CITY OF ALBUQUERQUE

RE: Highland High School Title IX Gymnasium Upgrade-Phase 1
4700 Coal Ave SE
Requested Permanent C. O. – Not Accepted
Engineers Stamp Date 6/23/16 (K17D021)
Certification dated: 10-16-18

Based on the certification provided in your submittal received 10/16/2018, the above referenced is disapproved for a Permanent Release of Occupancy by Hydrology. Before a permanent CO can be accepted the following comments must be addressed.

**C-100**  
SHEET OF

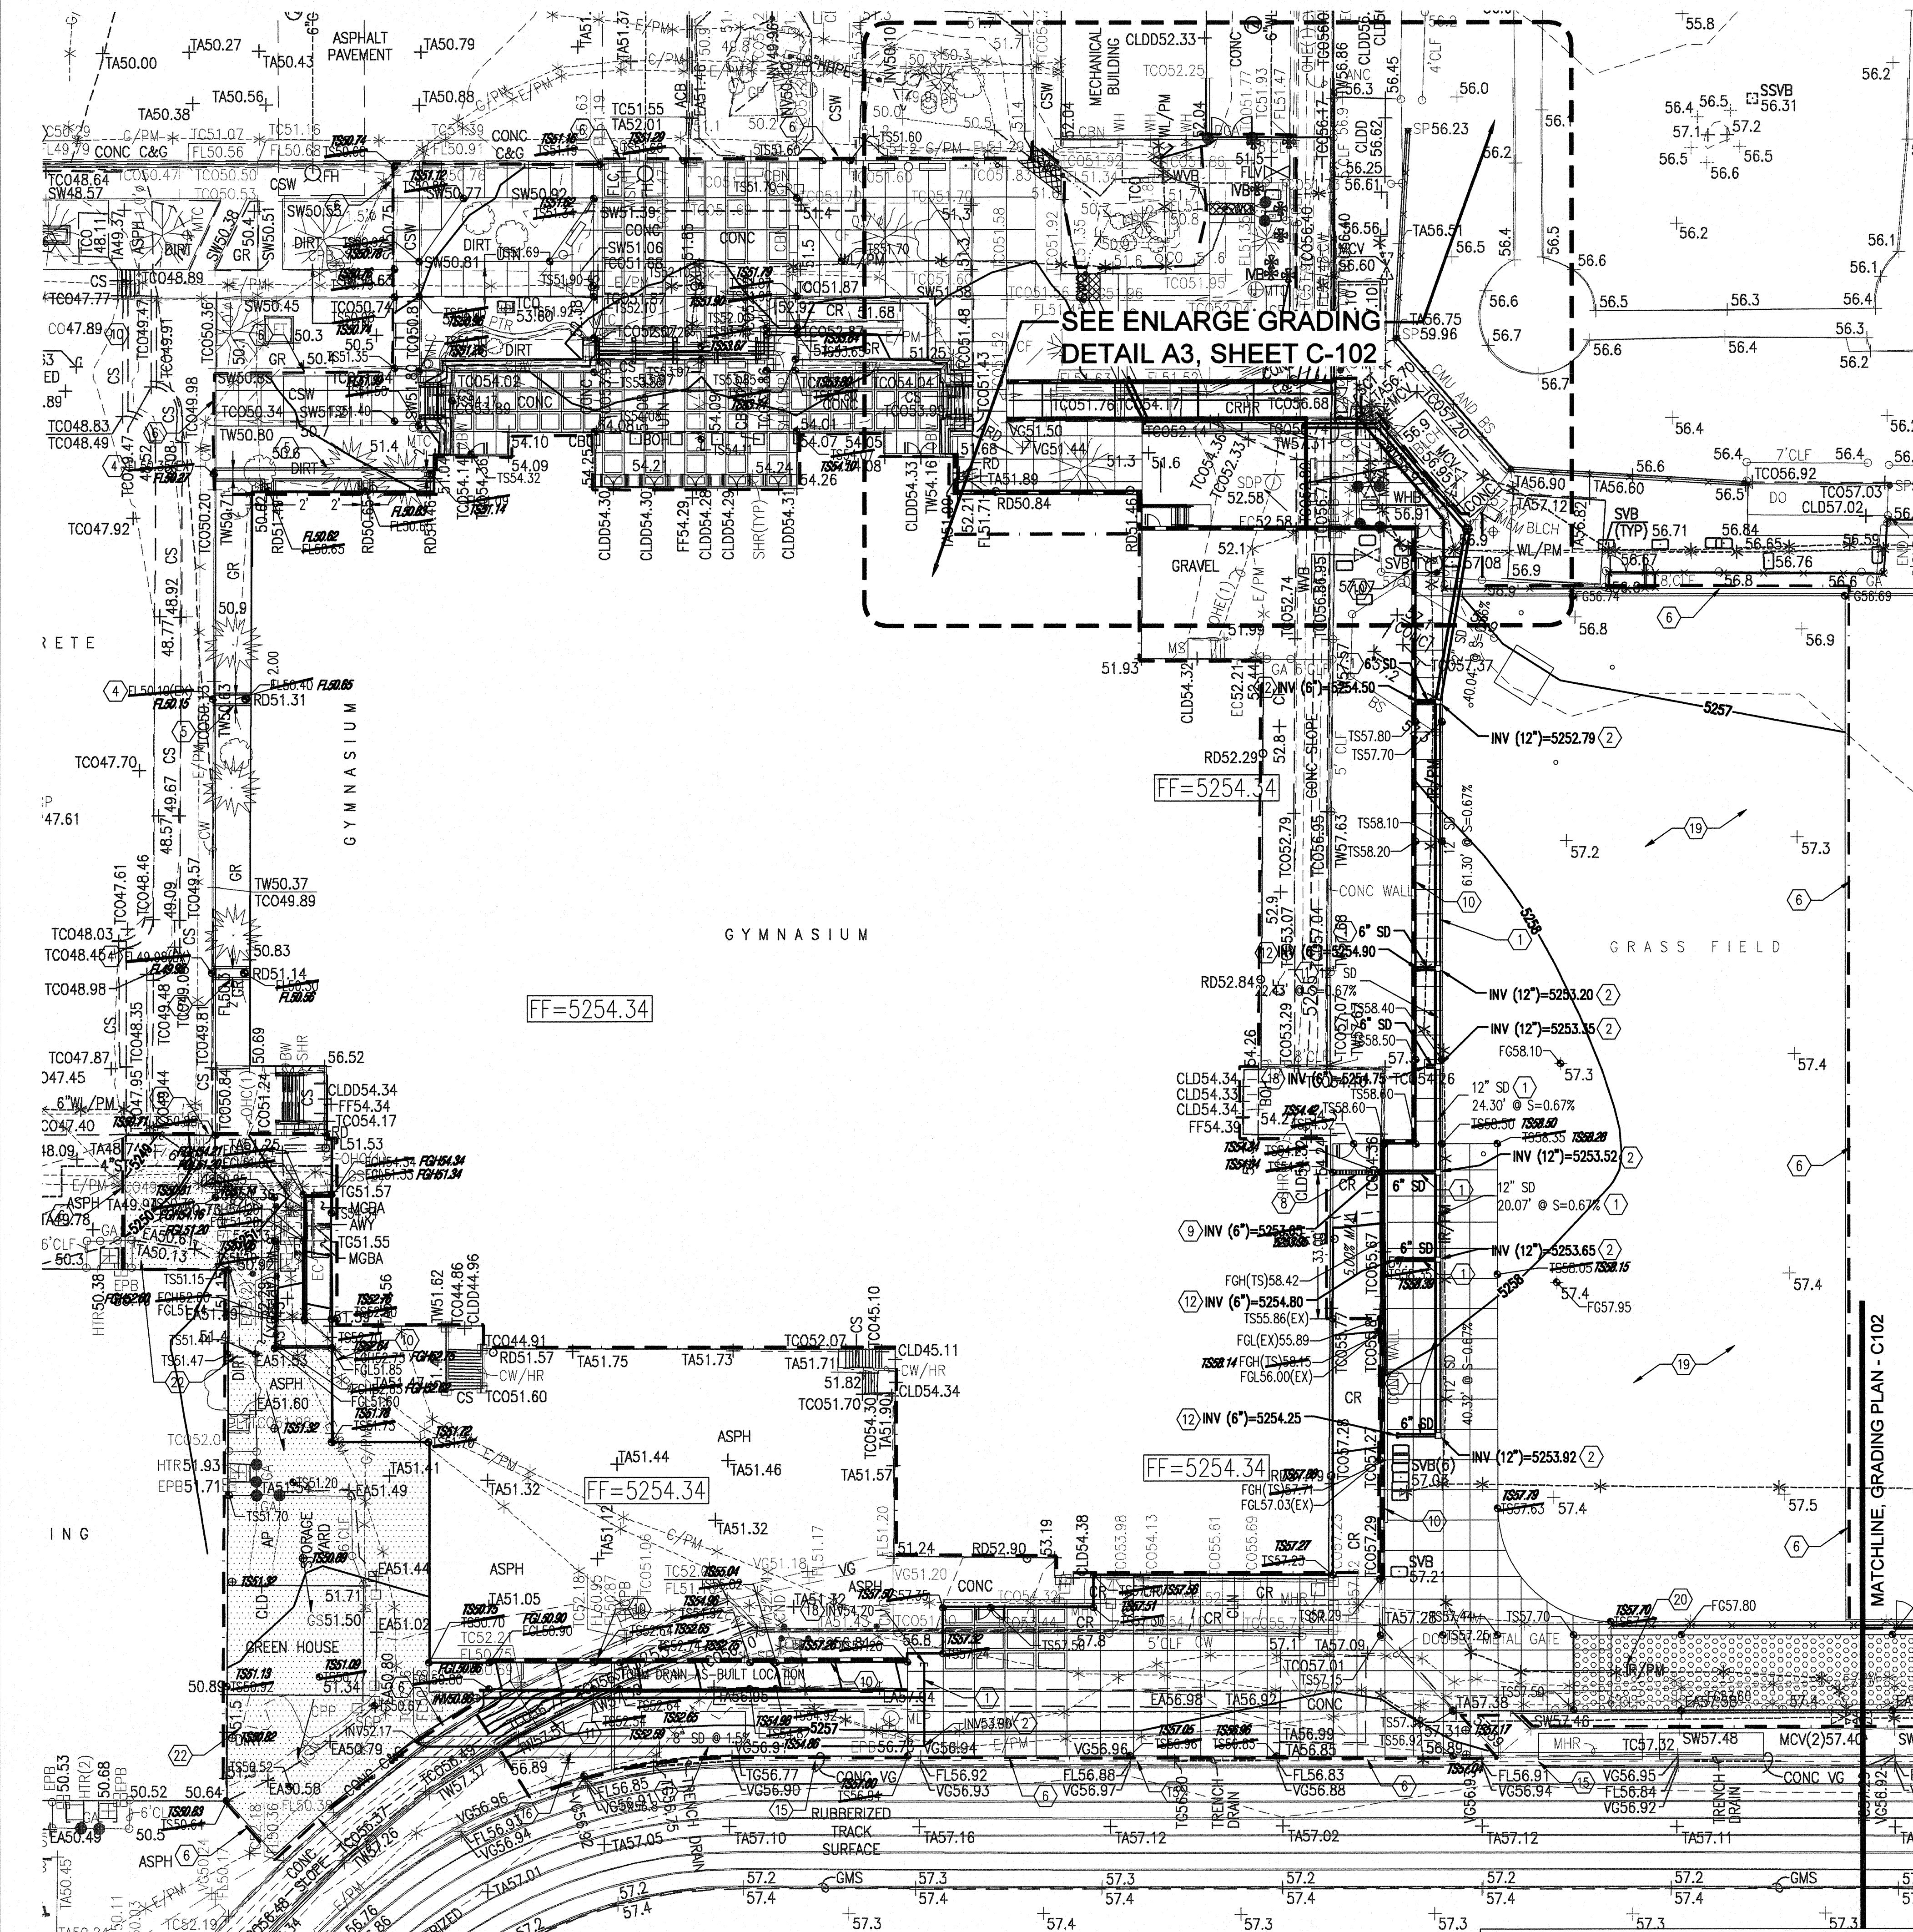
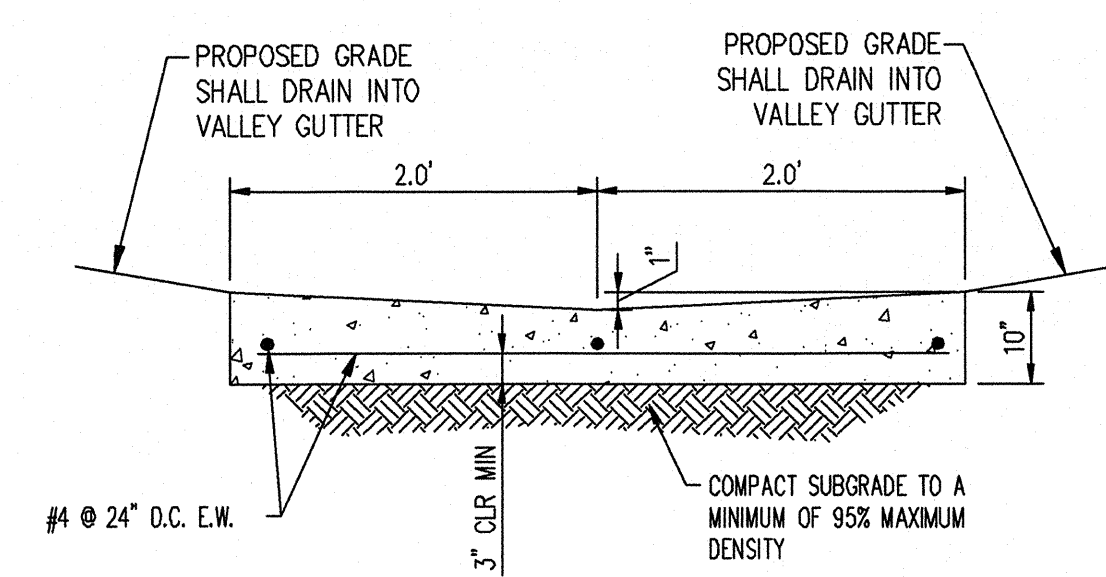
- All construction fencing is to be removed from Phase 1. See attached pic.
- The further most north double Sidewalk Culvert is incomplete. See attached pic.
- The Hydrology certification must be on the drawing, not a separate letter.
